**Our Case Number:** ABP-318802-24

**Re:** Proposed development of a resource recovery centre (including waste-to-energy facility)  
in Ringaskiddy, County Cork.

#### OBSERVATION ON SID APPLICATION

Case Reference: PA04.318802 (Ringaskiddy, Co. Cork)  
Proposed Development: Resource Recovery Centre (including “Waste-to-Energy” Facility)  
Applicant: Indaver NV t/a Indaver Ireland  
Observer Name: Rosemary Fitzgerald  
Observer Address: Glebe View, Galbally,  
Co. Limerick, E34CR29  
Contact Email: nochoc@gmail.com  
Date: 14 November 2025

Figure 2-4: OPW Flood Map

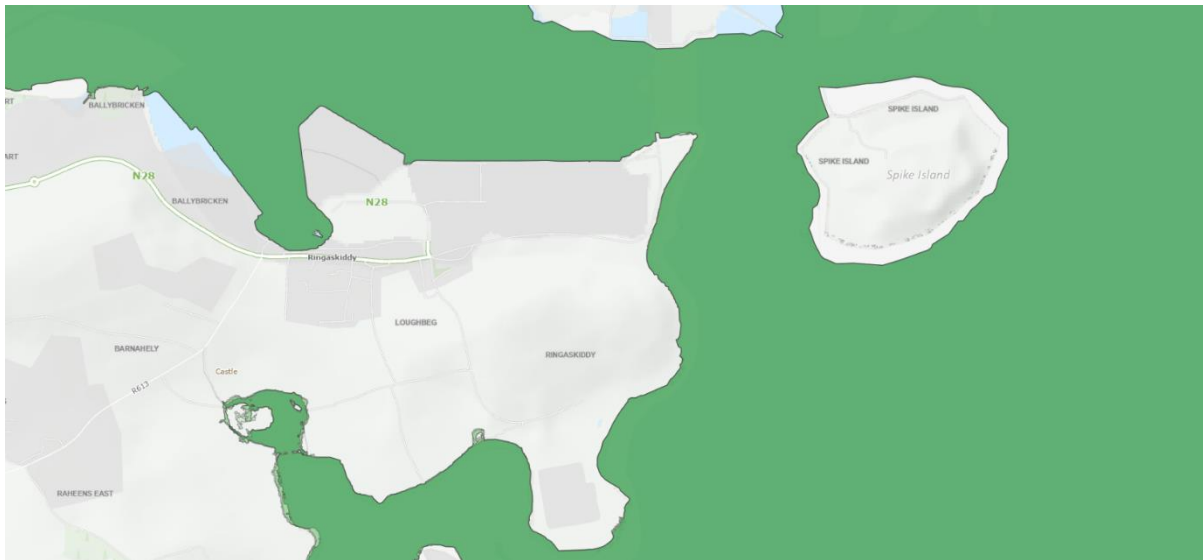
- OPW Flood-Risk Management Guidelines (2009 & 2022) – site lies within Flood Zones A/B; no dry egress;
- Cork County Development Plan 2022–2028 (zoning RY-I-09 – education/marine enterprise, not industrial); and
- NWMP 2024–2030 Target 1A (“no new residual-waste capacity”).
